# PORTLAND MAINE

December 31, 2007

RE: Waiver Request: Sheridan Heights – Allowable window area  
CBL: 013 K002  
Permit #: 07-981

1 Street wing (south)

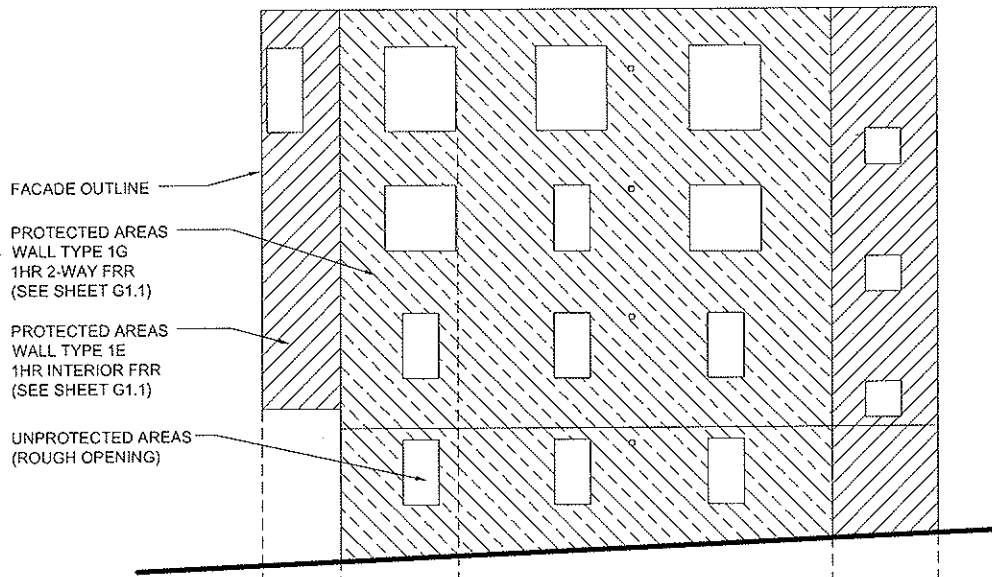
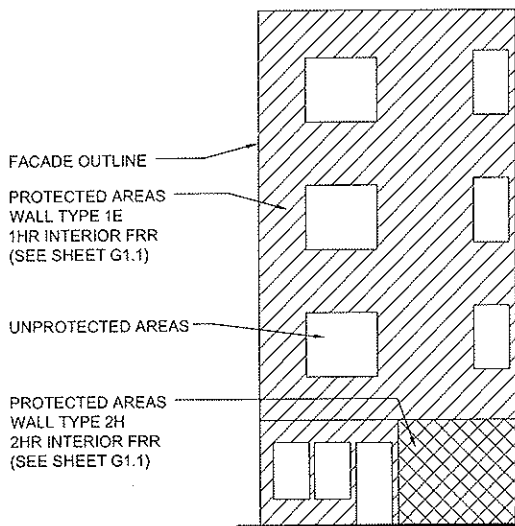
Thank you for your request for waiver to increase the percentage of opening protection in the exterior south wall bordering units 1A, 2A, 3A and 4A. Per the review from Mike Nugent, and the email on November 20, 2007, the following are the facts:

The openings in these units now will be considered "unprotected" because the project will have the dual NFPA 13 and NFPA 13R system as previously discussed. The request is to measure the fire separation distance to a line half way between the new building and the zoning setback point on the abutting property. The distance ranges from 6'9" to 8'9". Table 704.8 limits the allowable unprotected openings to 10%. The applicant proposes 14.6% of unprotected opening over this elevation. In order to approve this waiver, the following conditions will apply:

1. That additional fire suppression is installed in the interior of each window to increase the capability of the sprinkler system.
2. That the interior side of the exterior wall on this face has a 1 hour fire resistance rating. (This is required anyway).
3. That if development on the abutting parcel occurs in a manner different than contemplated by this proposed waiver, The City has the right to require upgrades to the Sheridan Heights project that would increase the level of protection including but not limited to: reductions in unprotected openings and / or increases in fire suppression.
4. The approval of the State Fire Marshal. (An email from Steve Dodge at SFM received on November 21, 2007 states that he and Eric Ellis have never had a problem with this).

The Waiver Request is approved by this office to increase the percentage of unprotected glazing at the south wall on the above mentioned project based on meeting the above conditions.
